From: Simon Davis
Sent: 30 April 2019 13:20
To: Planning.Responses
Subject: FW: BN/12/19/PL The Cottage Piggeries - Changes to Replacement Dwelling.
Attachments: C0117-P217.pdf

Proposed Roof Plan

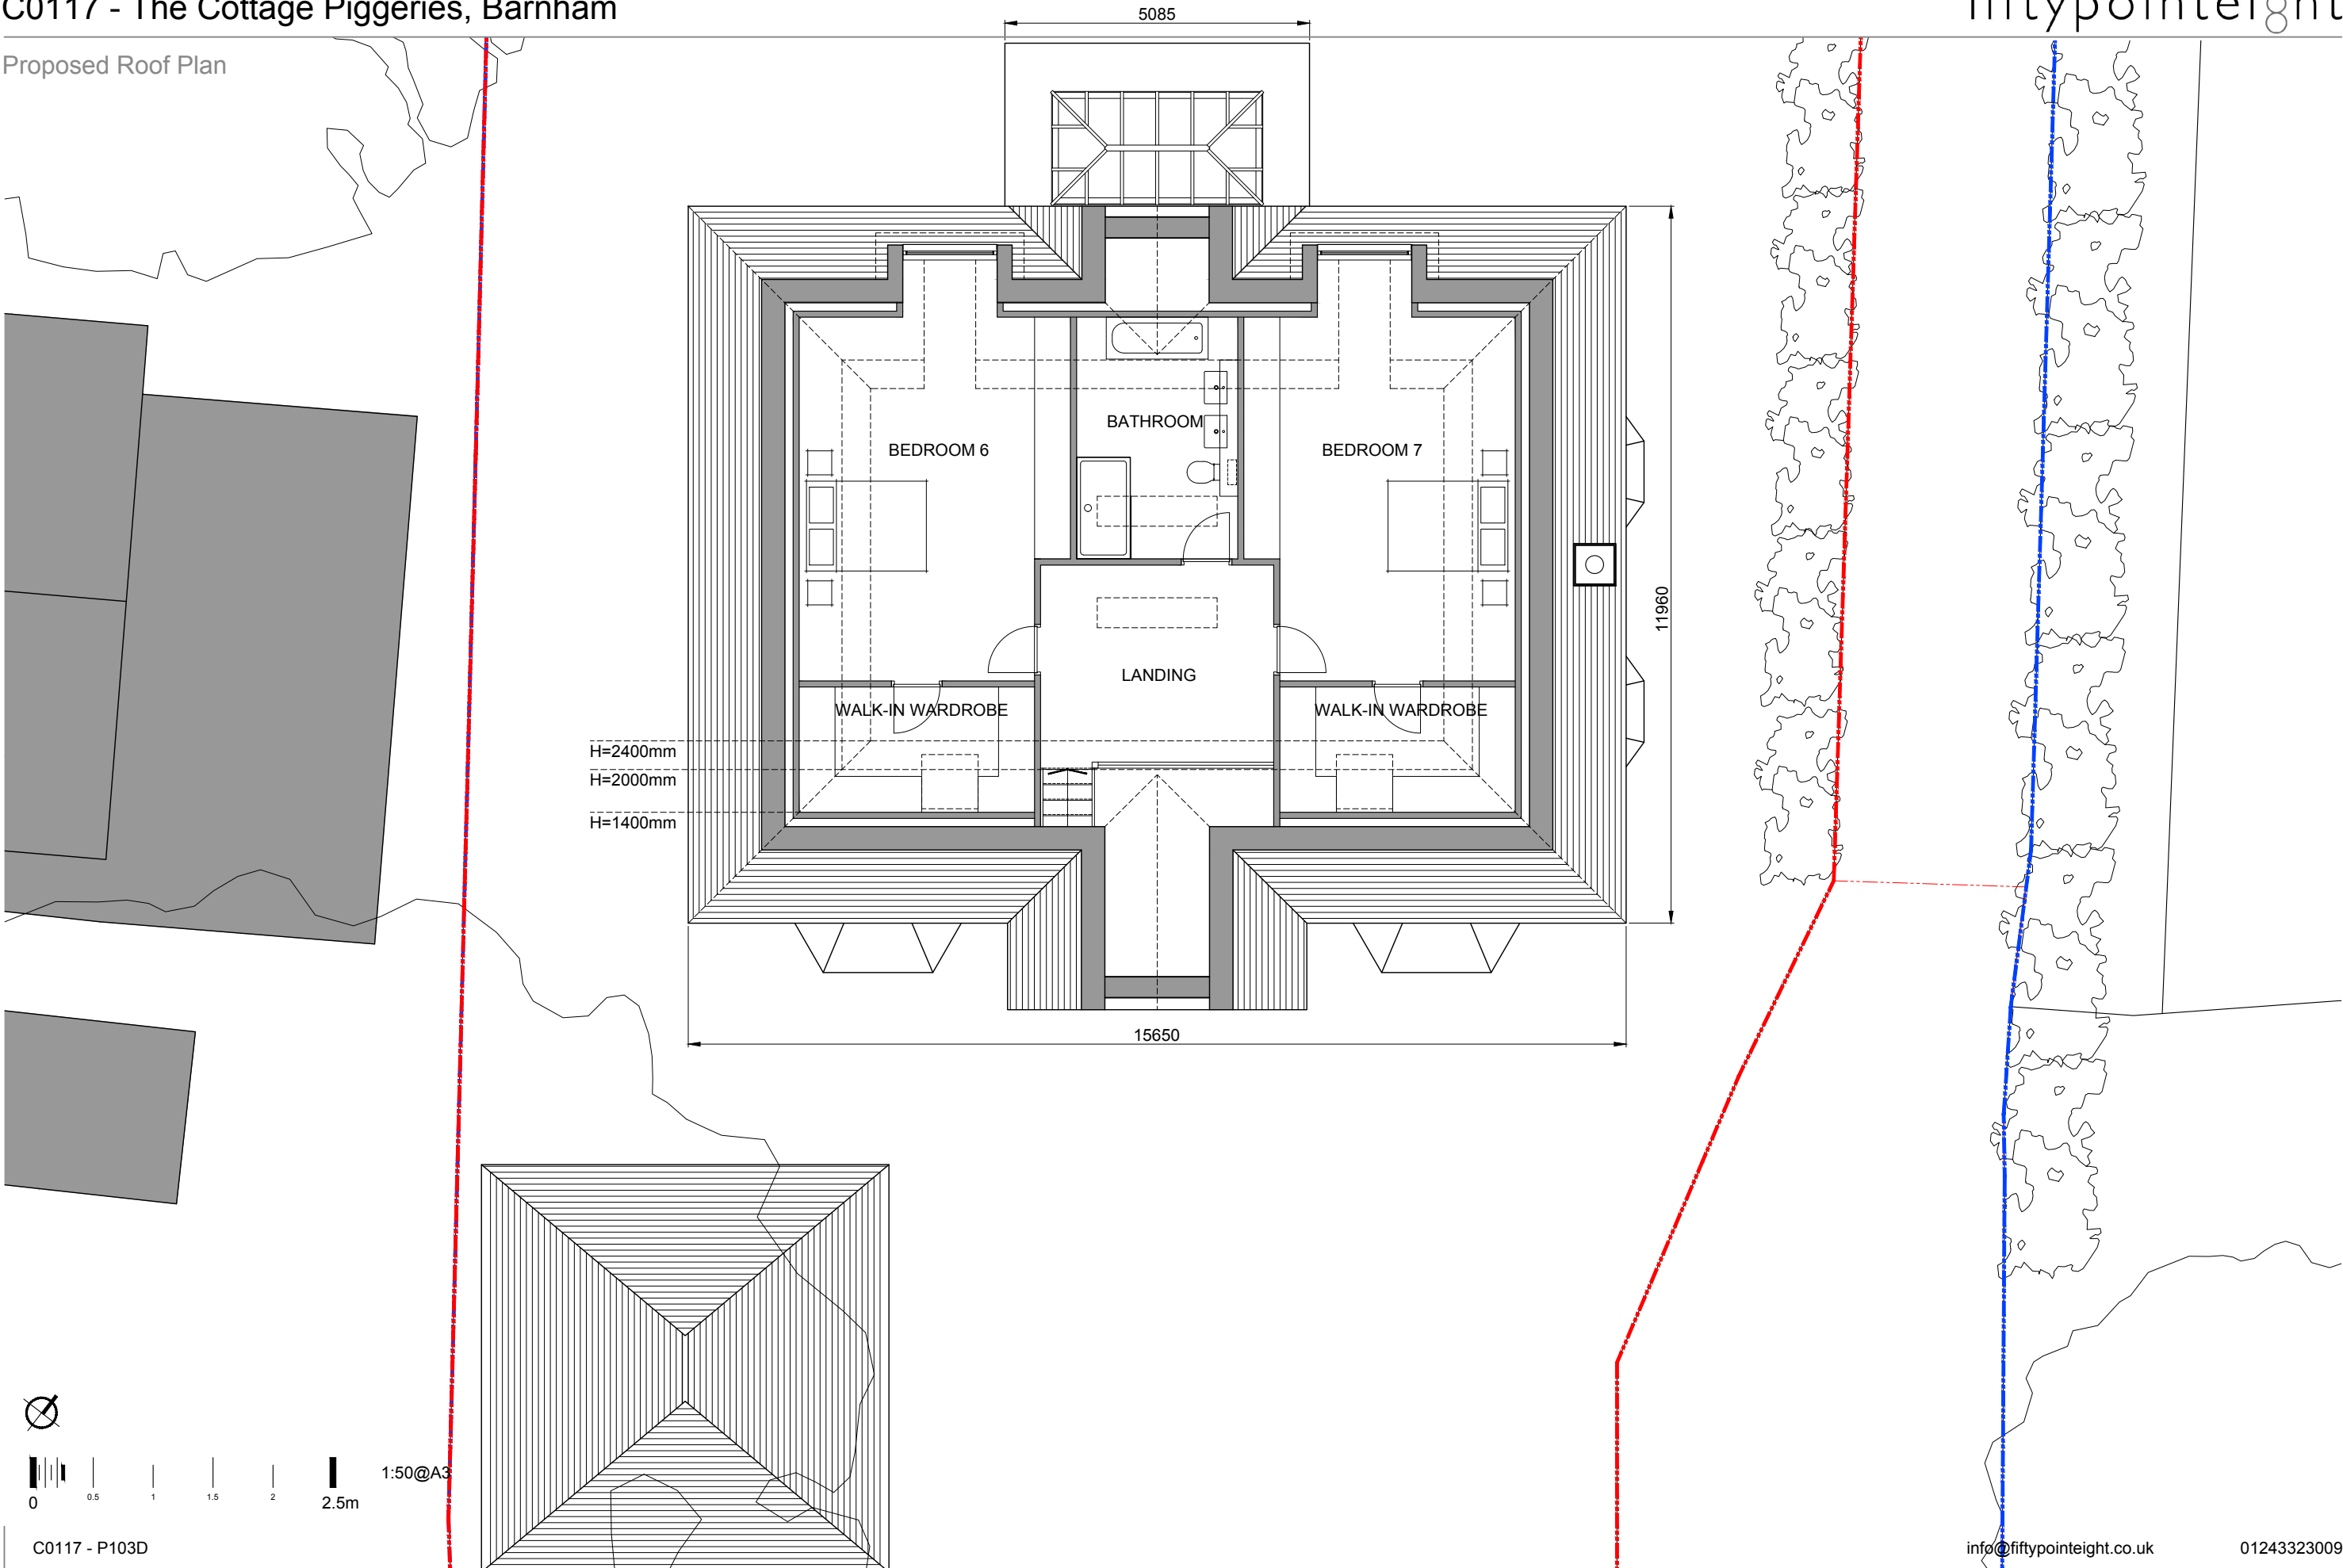
Proposed section attached, showing heights at velux positions.

I have spoken with Albert this morning and I said that I would have a think about how we are likely to recommend BN/12/19/PL for the additional accommodation in the roof. I have duly looked at the plans and consider it likely that we will recommend approval. At the present time this will be a delegated decision but this could change if we get a response from the Parish Council. Can you provide me with a cross section of the proposed roof level accommodation so that I can check the heights of the velux windows. Subject to this, we may or may not need to impose an obscure glazing condition on these two velux windows.

We are comfortable with a condition imposing obscured glazing on the two veluxes.
